**GRADING, EROSION  
AND  
STORMWATER QUALITY CONTROL PLAN  
FOR  
FALCON HIGH SCHOOL BUILDING ADDITION**

Prepared for:  
**FALCON DISTRICT NO. 49**  
10850 E. WOODMEN ROAD  
PEYTON CO 80831  
(719) 473-5321

Job no. 2366.92

Please add County  
project number

CONSTRUCTION PLANS
 DETAILED GRADING & EROSION CONTROL PLAN

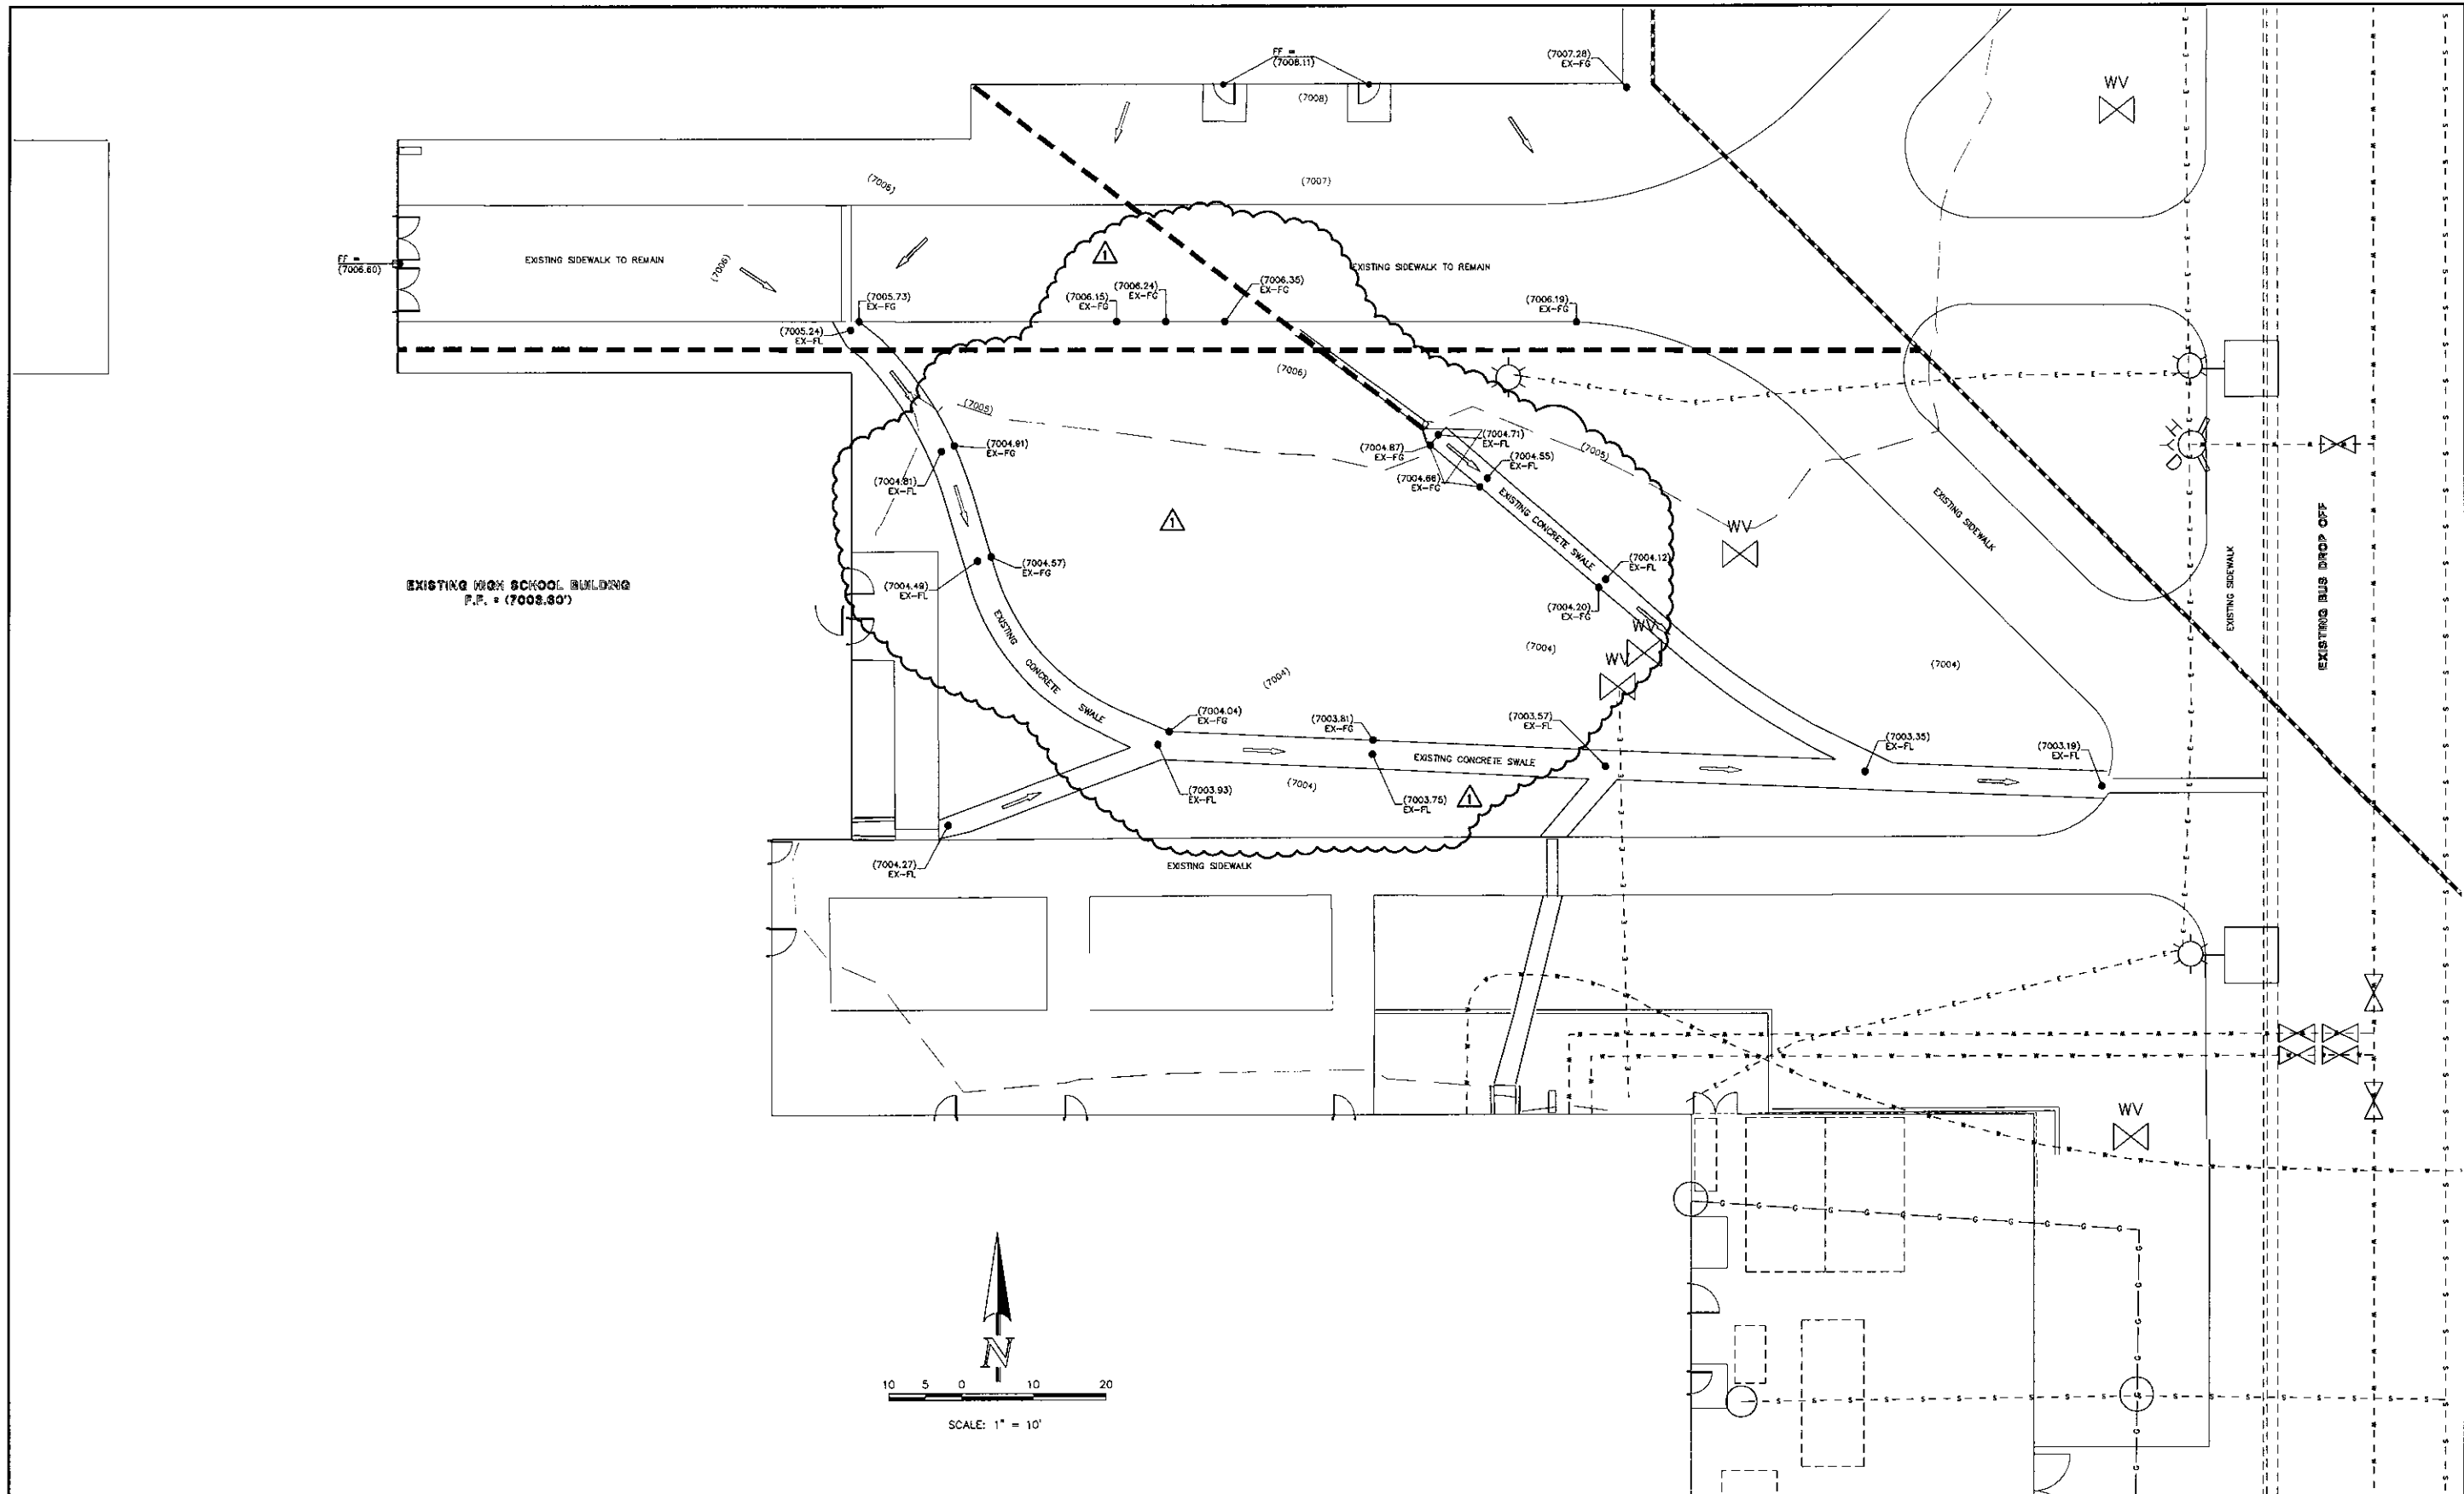
Please show on GEC plan or call out (on GEC plan) that contractor will determine once on site.

temp sedimentation basin not provided.
